646981

AGREEMENT AND COVENANT

Re: Sam's Club East - Albuquerque Store #6672-01 Drainage Report
Engineer's Stamp dated 7-14-00 (K21/D09F)

RE: Sam's Club East (K21/D09F)

SHEET # 6

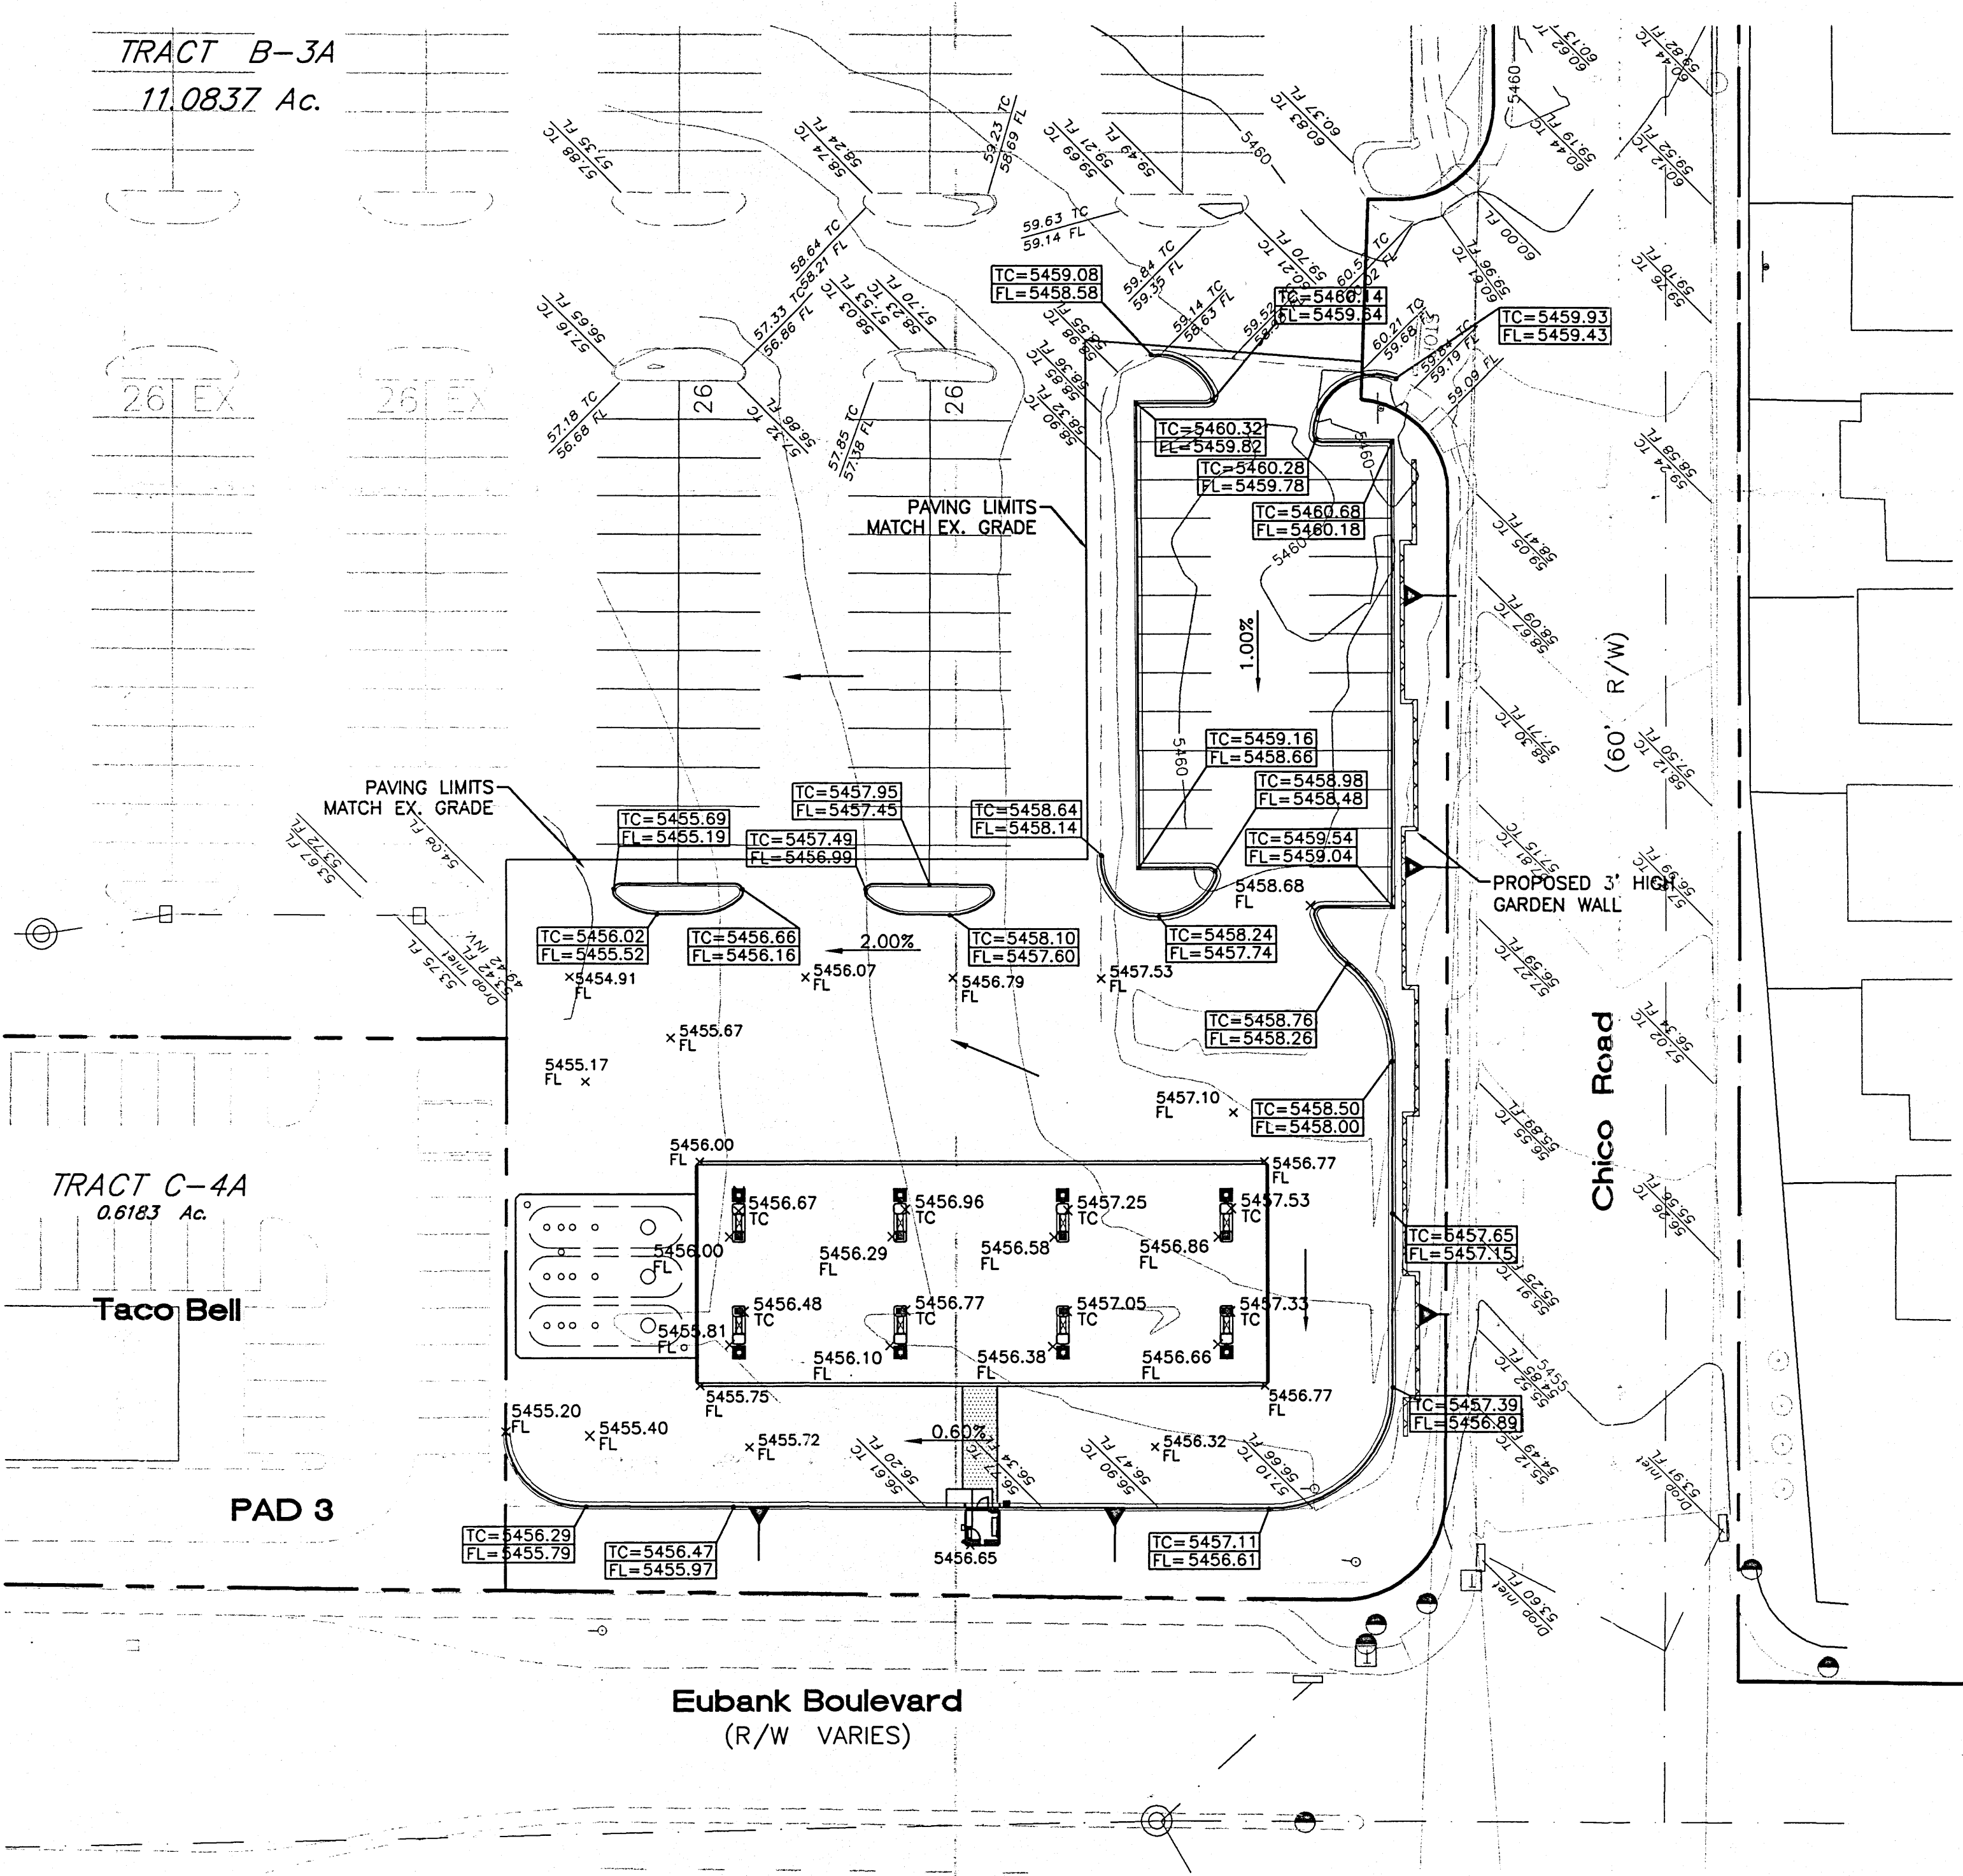
1. Please stamp the Grading Plan and make sure that it has the same date as the report. Also, the north arrow should point to plan left, not as shown.
The Grading Plan and drainage report have the same stamp date. Also, the north arrow has been corrected on the Grading Plan and in the report exhibits.

2. Please add and label the pipe work needed for interim and ultimate conditions. Also, add any reference to orifice plates as needed.
We labeled all pipes needed and included the orifice plate at the pond. We have revised the AHYMO to show the pond draining to the Towne Park Plaza storm drain system. The pond discharges 7.48 cfs to the system. However, the peak flow from the pond reaches the system after the peak has passed for Towne Park Plaza. Consequently, the pond only increases the flow to Eubank by 0.1 cfs. We are no longer showing an ultimate and interim solution. Since the pond has no adverse affect on Towne Park Plaza, it will continue to drain there in the future. A storm drain connection to the Cinemark system is no longer needed.

3. You will need to adjust the invert at your proposed Double D inlet and also provide inverts at all pertinent manholes as well.
We have shown inverts at all inlets and manholes on the site.

4. Show the Water Surface Elevation in the pond
This is now shown on the Grading Plan.
5. Demonstrate downstream capacity within the Towne Park Plaza storm drain system for the discharge from the pond.
This has been shown in the new AHYMO included in the drainage report. The system has capacity for the additional flows.

6. Clean up the notes on the Grading Plan and various typos in the drainage report.
The notes on the Grading Plan were revised and the drainage report checked.
